Appendix D Supplementary responses

COMMENTS REGISTER			
Project Name:		Panorama BESS	
Client Project Manager:		Christopher Smith	
SLR Project No:		660.v30234.00003	
SLR Project Manager:		Charlie Seventekin	
Revision:		v1.0	
Revision Date:		Wednesday, 16 April 2025

ARES PROJECT SERVICES PTY LTD - ABN: 45 643 587 115

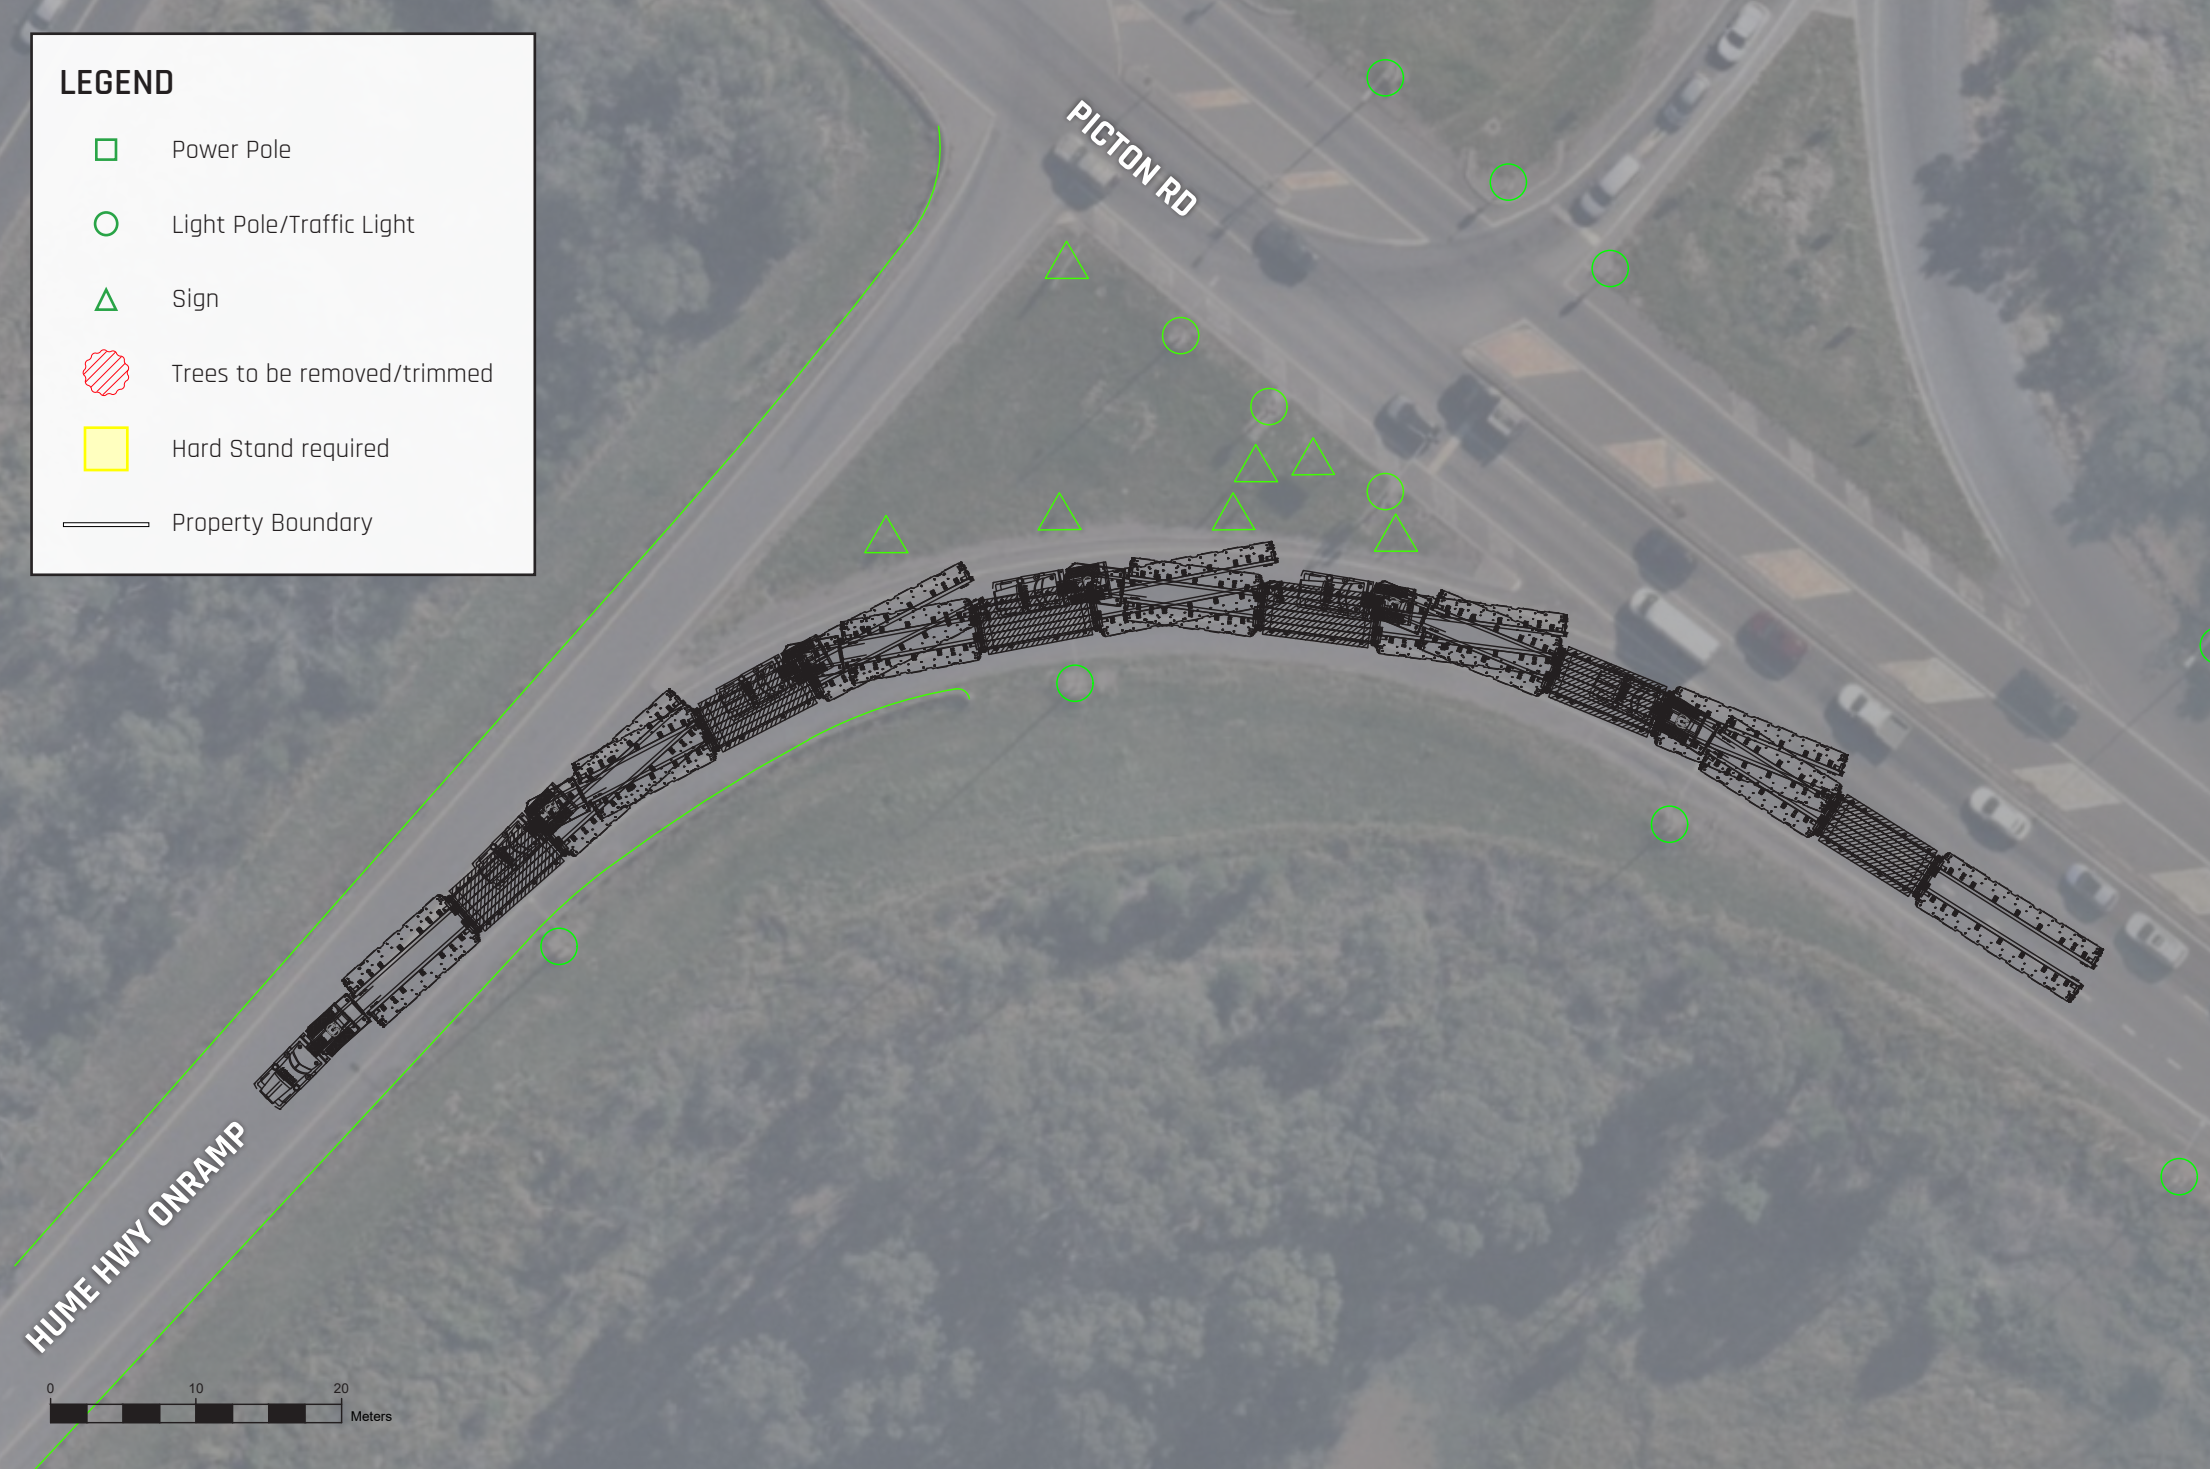
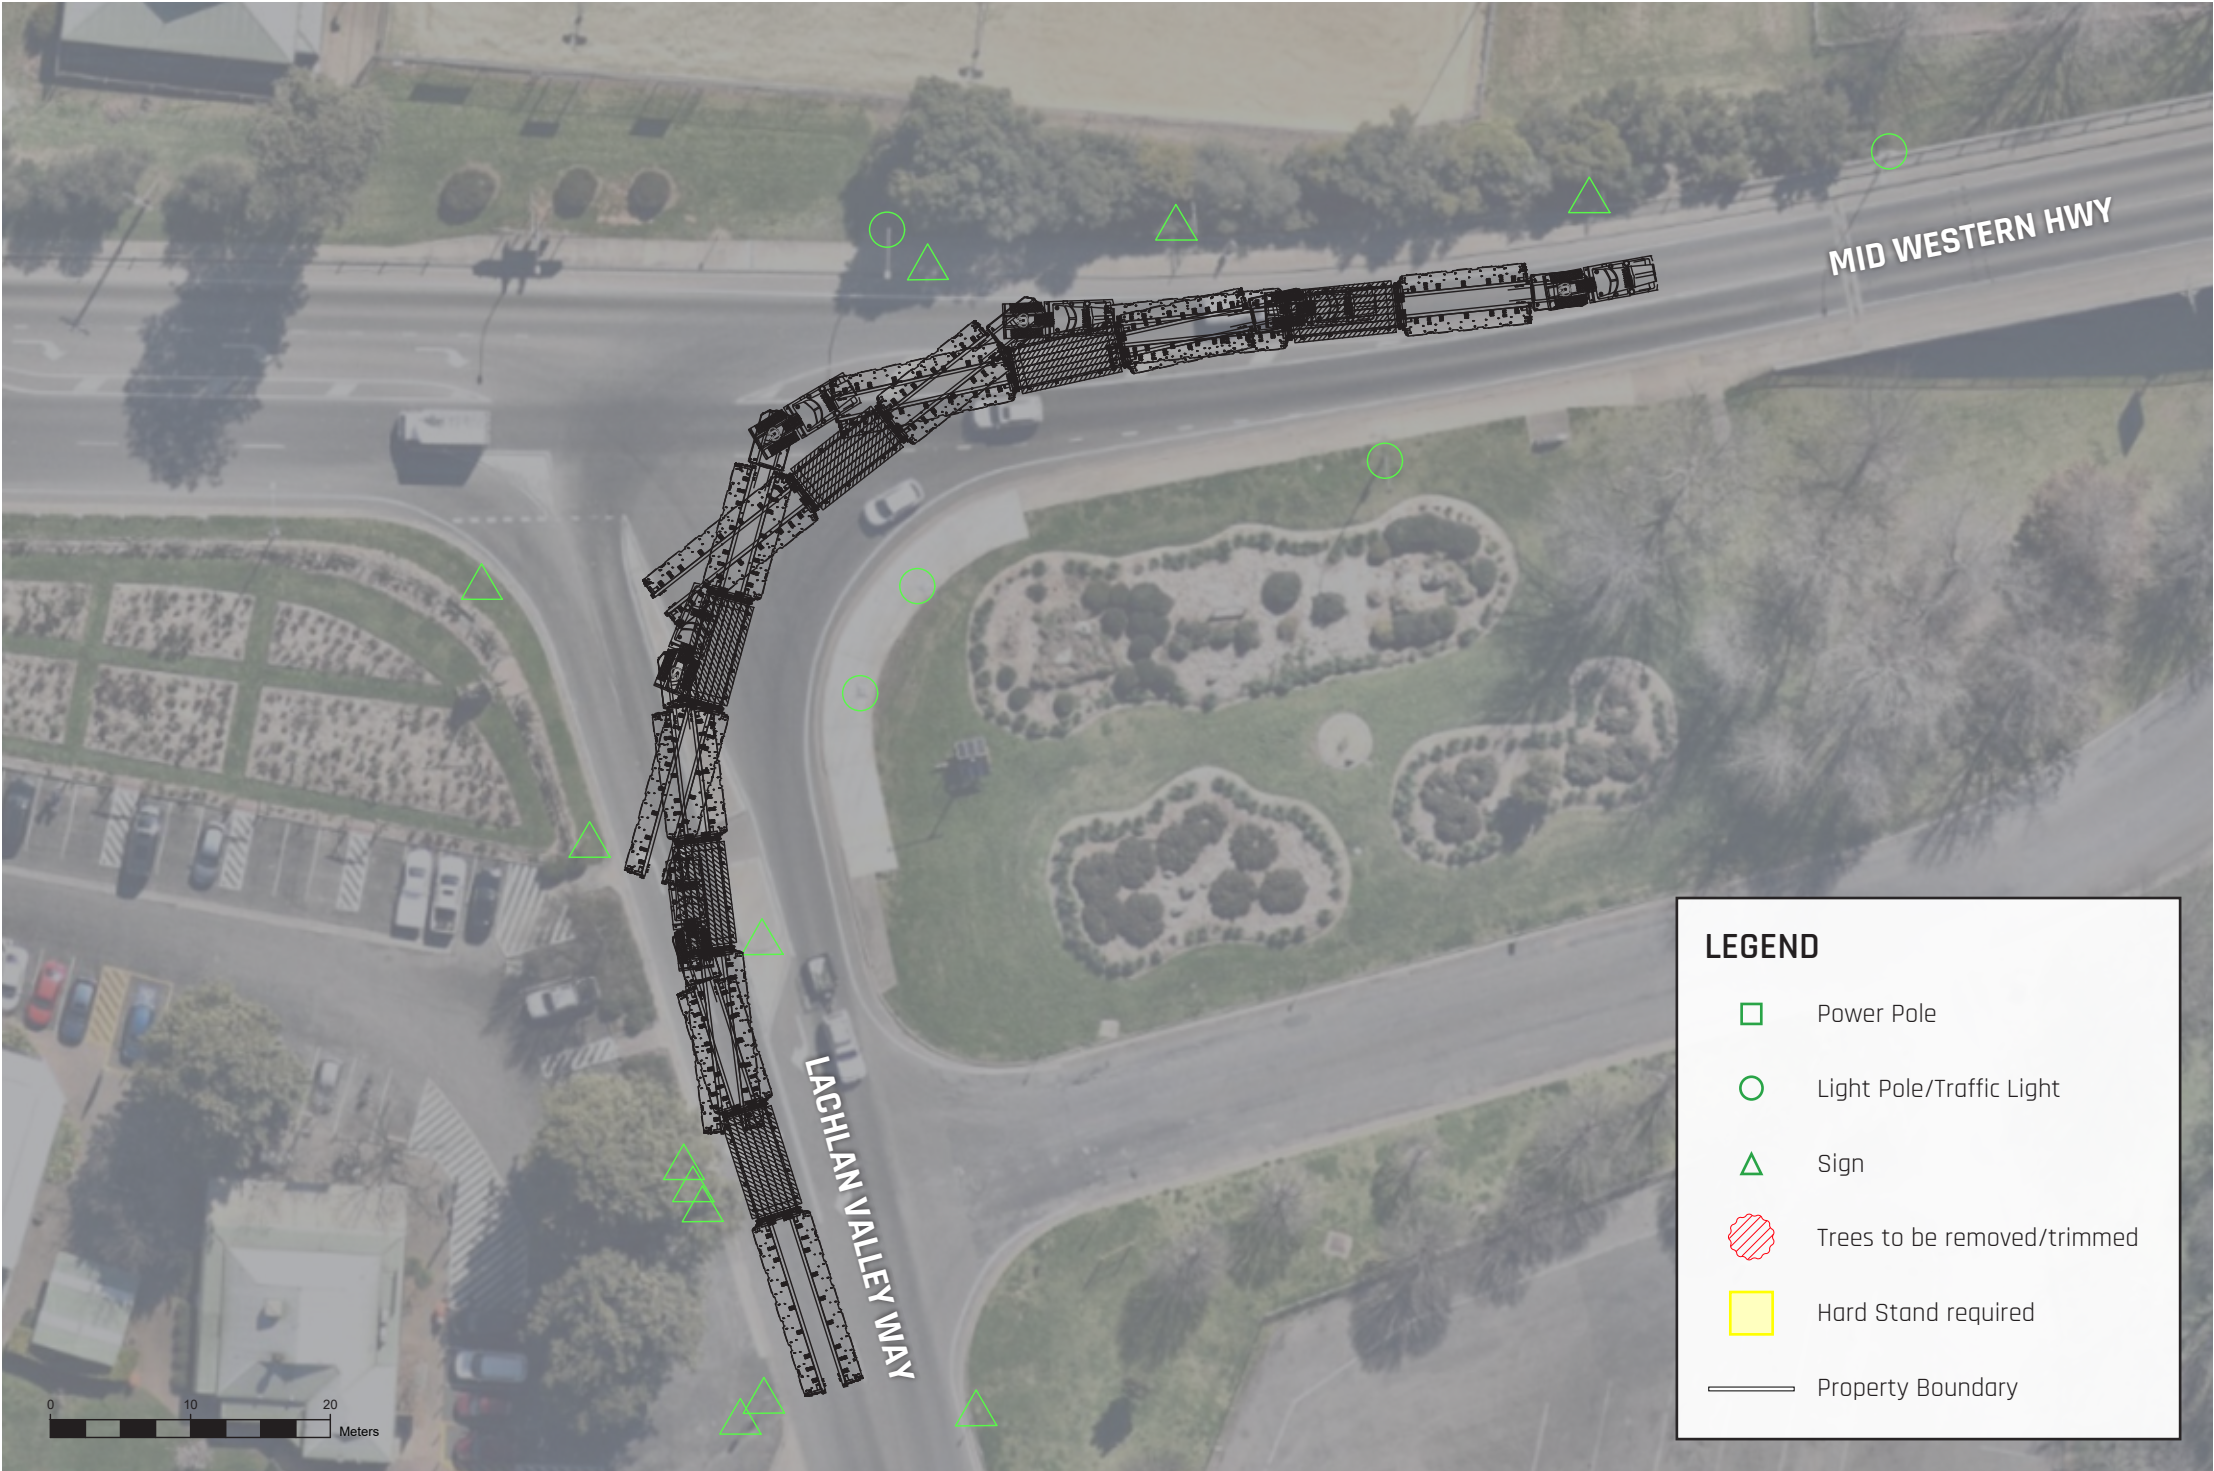
6	OSOM vehicle for the transformer is classified as high risk OSOM (as defined on TfNSW website in this link) due to its proposed height exceeding 5.20m. A Concept Level Route Analysis is required with the following information: • The route from port or point of origin to site access and intersections required to facilitate high risk OSOM movements required for the project. • Details of all high risk OSOM loads and vehicle configurations for the project. • Location of pull-over bays / rest areas along the high risk OSOM routes (including GPS coordinates) and demonstration swept paths of high risk OSOMs can be physically accommodated (in terms of size, width and accessibility). • Road geometry details and alignment along identified transport route(s), including existing formations, crossings, bridges, intersection treatments and any identified hazards, including: o Bridge Assessments for any at risk bridges on the classified road network due to dimensions and weight of OSOM vehicles. o Swept path analysis demonstrating the largest design vehicle can enter and exit the site and simultaneously pass through intersections along the proposed transport route(s). o Design vehicle templates used in the swept path analysis software in order for TfNSW to review performance (e.g. Autodesk Vehicle Tracking or Transoft AutoTURN). o Highlighting each at-risk road structures that haulage route(s) cross including bridges, traffic signals, signage, major culverts and minor culverts that may not meet desirable cover to cater for proposed axle loads. • Identify and provide the following measurement parameters of OSOM components / materials to be moved: o Types and numbers of high risk OSOM vehicles. o Overall combination type, configuration, load and vehicle configuration. o Wheelbase dimensions. o Length, width, height and mass (GCM, tare, weight to axle and payload) for components and nominated vehicles. o Maximum trailer articulation angle(s). o Minimum overhang heights above the road surface. o Vehicle configurations. o Traffic mitigation measures or road works, modifications or road upgrades to facilitate the movement of high risk OSOM(s). o Potential high level mitigation measures or commitments to mitigate known traffic, safety and impacts to road users along the high risk OSOM route(s) (i.e school bus routes, mining shift changes, TSRs, harvest periods and events). • Identify and assess implications of any road and rail projects that may be under construction during the indicative schedule for the OSOM movements. Note: NHVR permits do not cover road works or upgrades and environmental approvals required for proposed OSOM route(s). Any road works or upgrades works required along the OSOM route must be included within scope of works in the SSD to ensure constructability. Note: Given high number of renewable energy and other large scale projects requiring haulage of OSOM components on the road network, restrictions and limitations on OSOM movements may be imposed. In this regard, it is recommended you engage early with TfNSW's Development Services Renewables team to discuss the requirements of the route assessment.	ADDRESSED IN SECTION 2.5.4 and Appendix H.	Reference is made to TfNSW request in Section 2.5.4.
